PLANNING APPLICATION CONSULTATION RESPONSE

Application Number:	3/2024/0257
Proposal:	Approval of details reserved by condition 14 (verification report and operation and maintenance plan for SW drainage) from planning permission 3/2021/0205.
Location:	Land at Neddy Lane Billington BB7 9LL

Lead Local Flood Authority Position

Drawing Title: **S104 DRAINAGE LAYOUT**

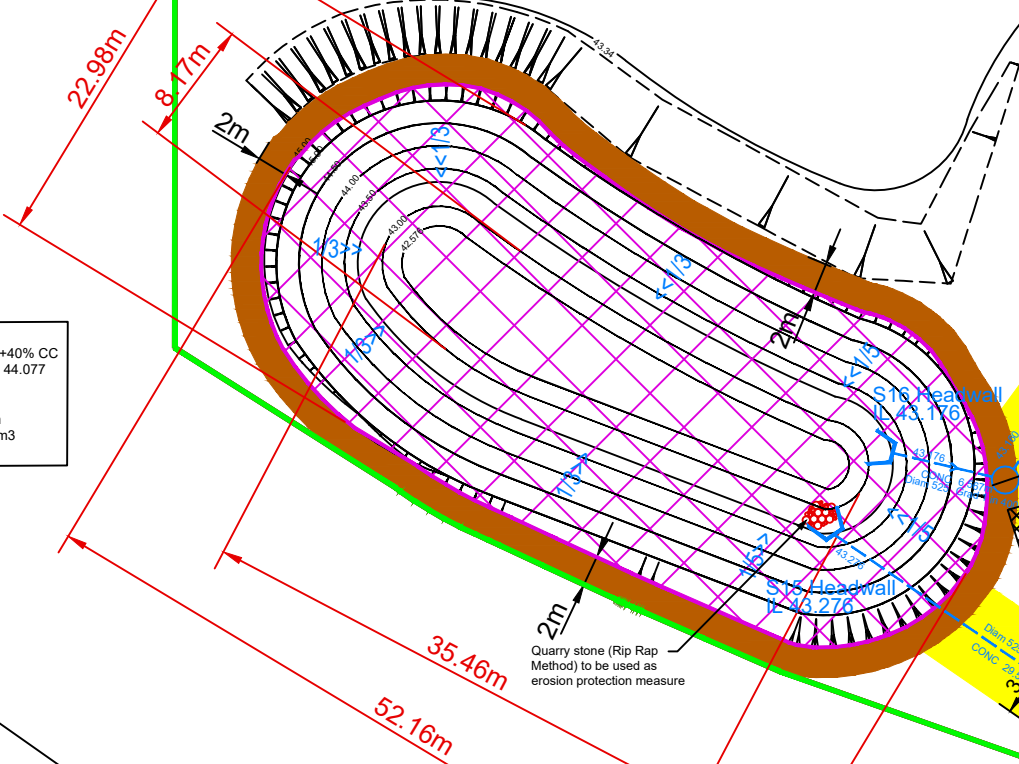
- The applicant has failed to provide supporting evidence of photographs as outlined in the condition of the SuDS components that are not to be adopted by the Water and Sewerage company to ensure that these have been constructed in accordance with the approved details.
- The applicant has failed to provide evidence of details of the maintenance, operational and access requirement for the attenuation basin.

- The applicant has failed to provide evidence of a pro-forma to allow the recording of each inspection and maintenance activity, as well as allowing any faults to be recorded and actions taken to rectify issues for the attenuation basin.
